Department of Transportation

June 11, 2020

RE: Falcon Fire Protection District - 7030 Old Meridian Road
Approval of Location

NEW STATION SITE PLAN  
FALCON, COLORADO

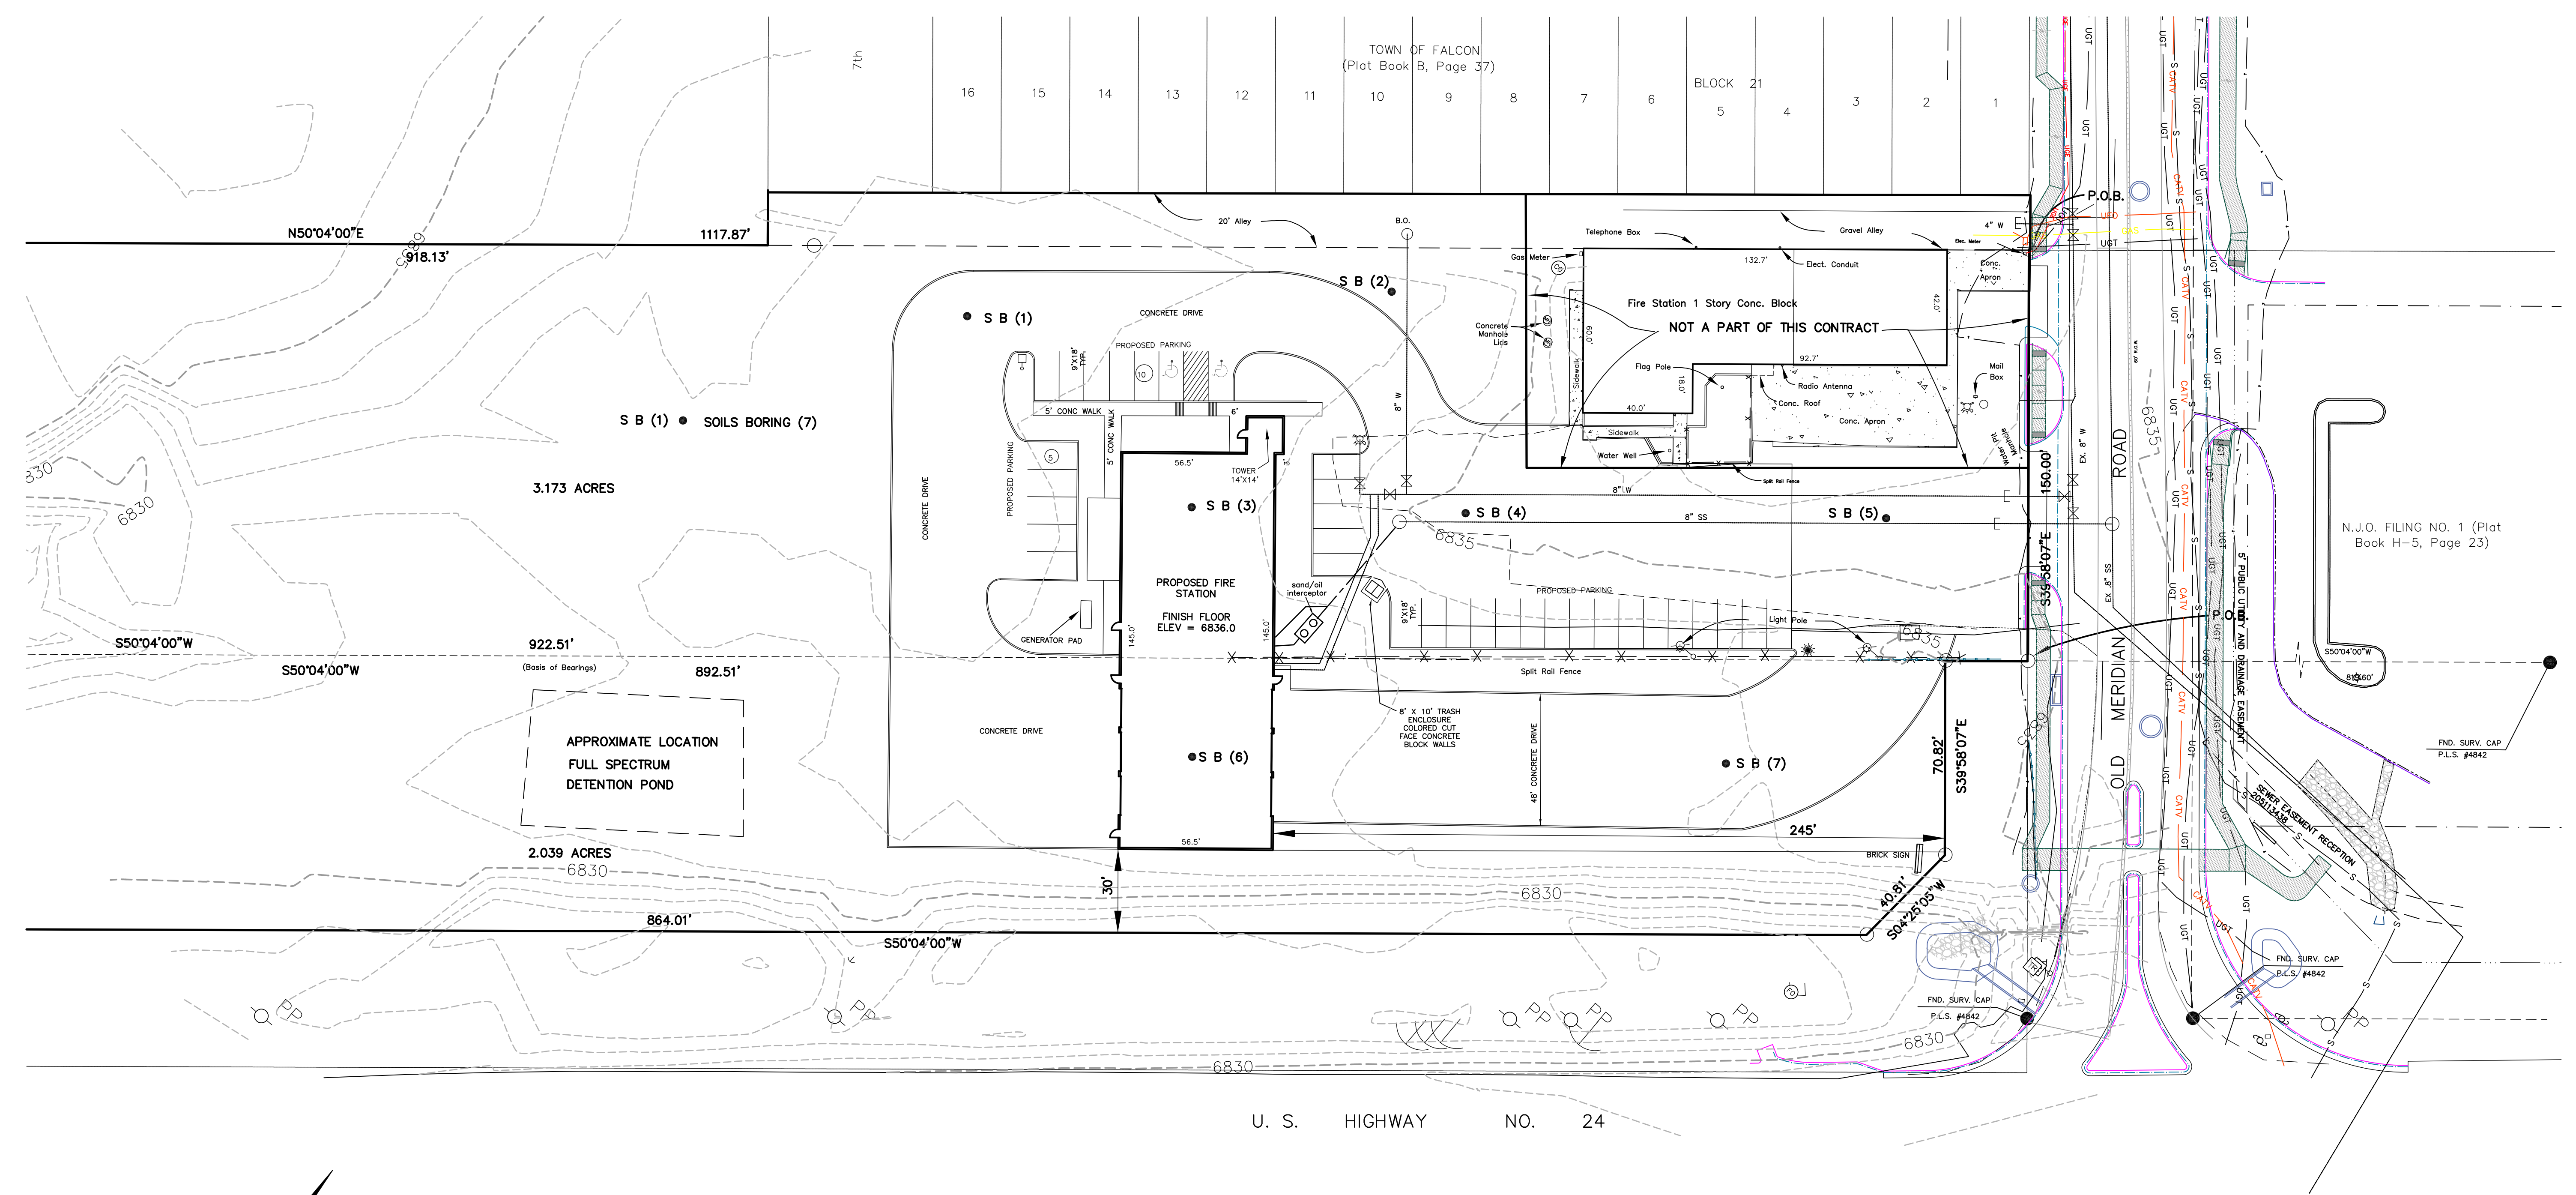
- Location Approval to allow Falcon Fire #3 to perpetuate will not impact CDOT infrastructure.
- Exceptions were made in the improvements to Old Meridian to allow a mountable curb for the fire station's use. If this property is ever used for anything other than for emergency services, use of the mountable curb will be illegal.
